Your Ref: 2025/92541

7th January 2026

Land off Roslyn Avenue, Netherton, Huddersfield - (KIRK) Operational development to create development plateau comprising land level changes, highways construction, utilities diversions and drainage construction

YorkshireWater

Proposed Drainage Scheme Plan

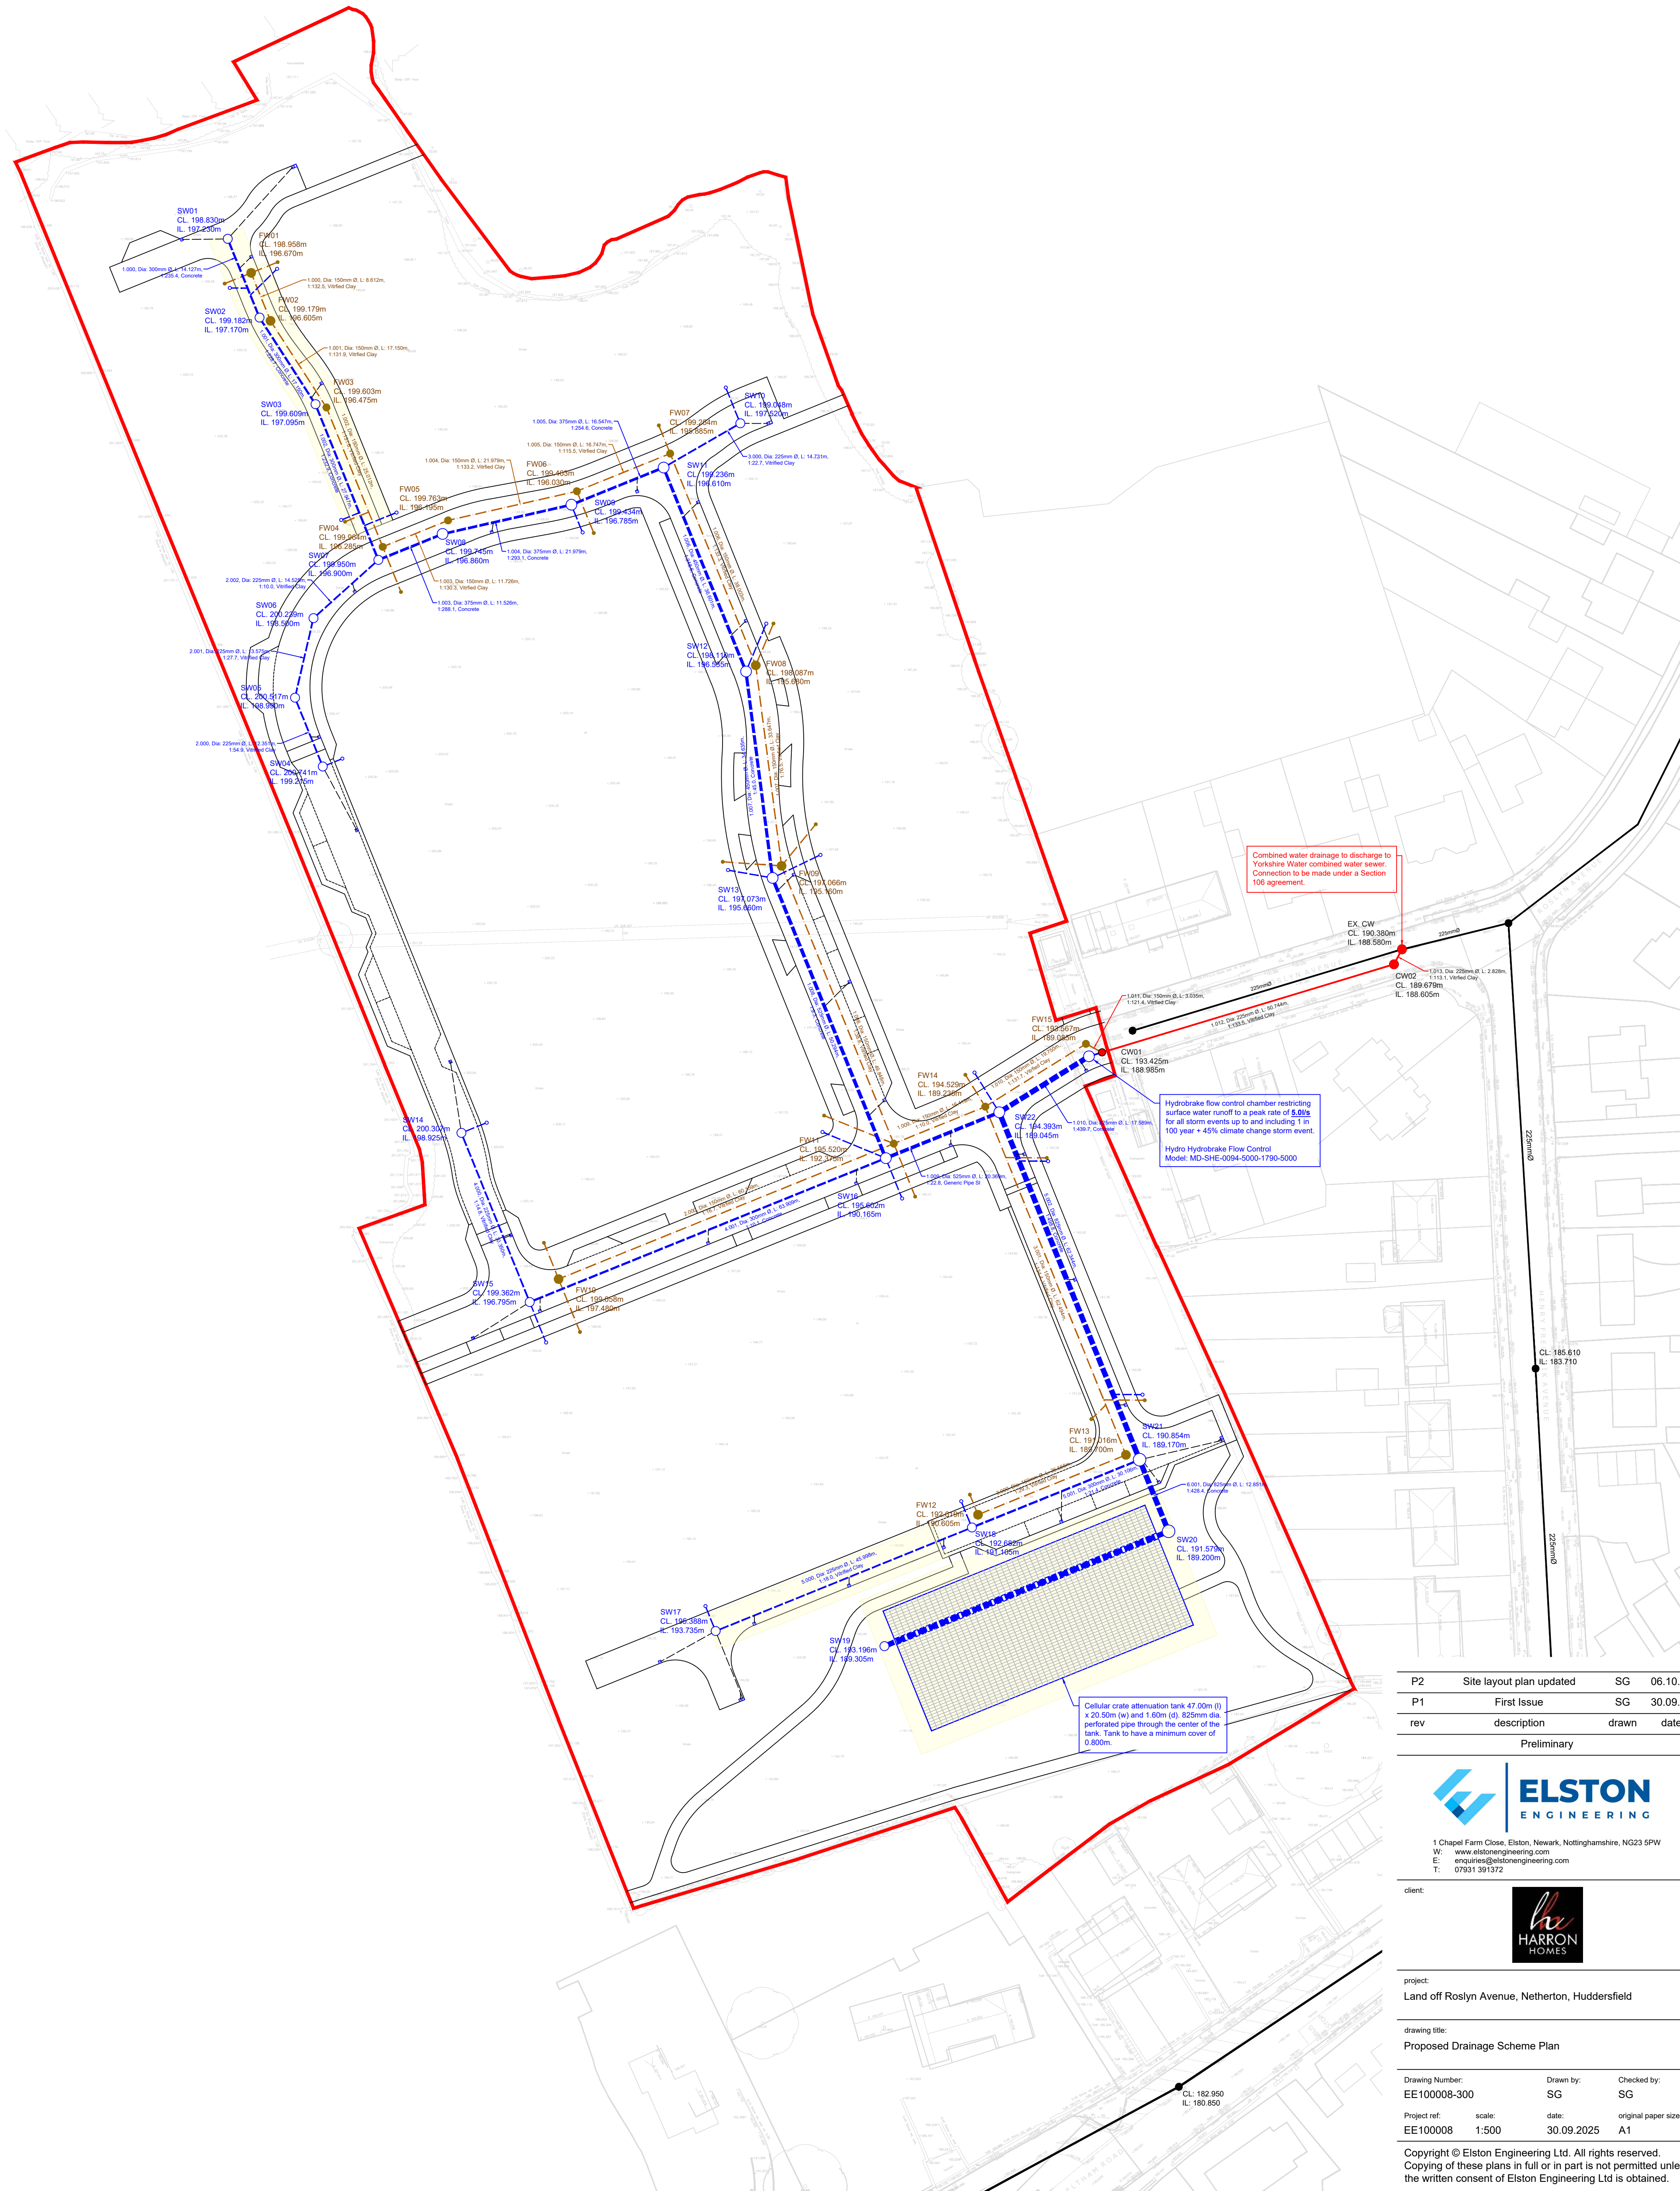
- a) Foul water will discharge to public combined sewer network
- b) Sub-soil conditions do not support the use of soakaways
- c) The site is remote from watercourse
- d) Surface water will discharge to the public combined sewer network at a restricted rate of 5 litres/second.

The means of surface water management has not been properly considered within the drainage report. The report fails to acknowledge the presence of a public surface water sewer 200 metres south of the site. This appears an obvious place for surface water disposal when taking the statutory powers of Section 98 of the Water Industry Act 1991 into consideration.

2) The developer is proposing to discharge surface water to public combined sewer however, sustainable development requires appropriate surface water disposal.

a) Yorkshire Water promote the surface water disposal hierarchy and the developer must provide evidence to demonstrate that surface water disposal via infiltration or watercourse or public surface water sewer are not reasonably practical before considering disposal to public combined sewer.

b) It is understood that a public surface water sewer and a watercourse are located to the south of the site. These appear to be more sustainable places for surface water disposal.
